**From:** Dawn Appleton [REDACTED]  
**Sent:** 10 May 2019 16:22  
**To:** Anita Gardner  
**Subject:** RE: FG/29/19/PL - South Point, Ferring ,

**Subject:** FG/29/19/PL - South Point, Ferring ,

I am in the process of writing the report for the above application with a view to taking it to the next Development Control meeting on 05-06-2019. I would therefore appreciate your Agreement to an Extension of Time until 07-06-2019.

PLANTING AREA 07

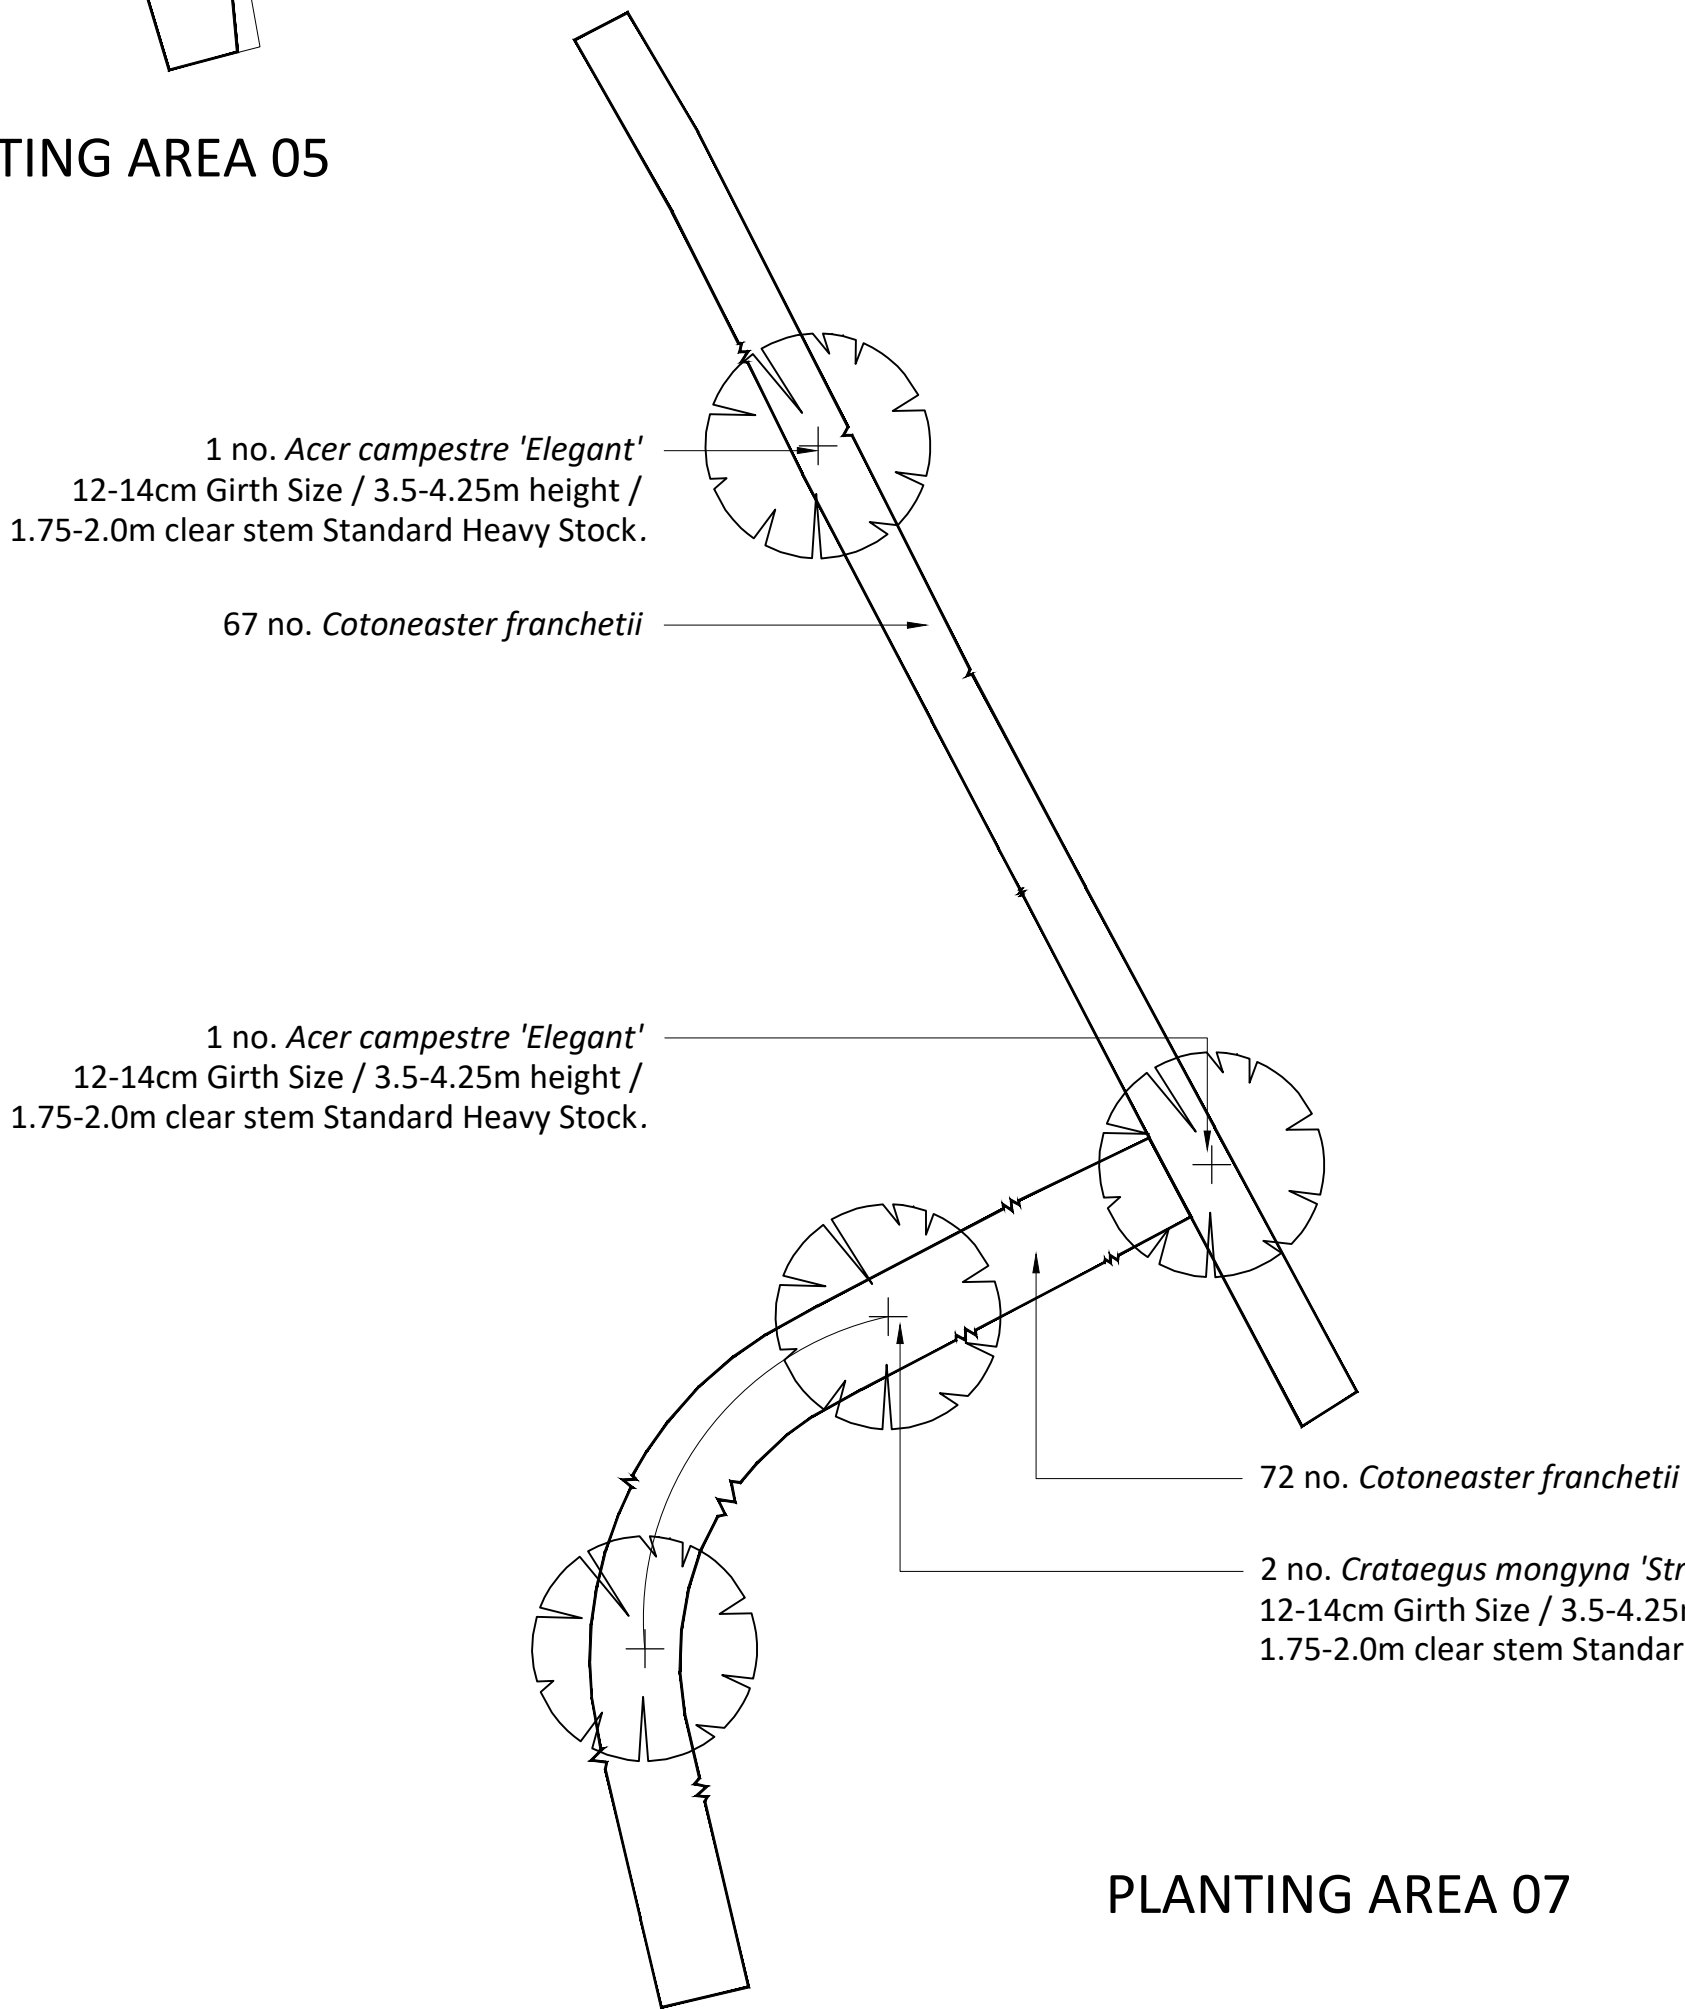
I would also appreciate clarification with regard to landscaping to the rear of the site adjacent to the parking area. As far as I can tell this area is not clearly identified and labelled on the submitted landscape plan. If it is can you confirm the bed planting number? Without this details are likely to be conditioned.

The landscaping area that I think you are referring to is the curved part of area 07:
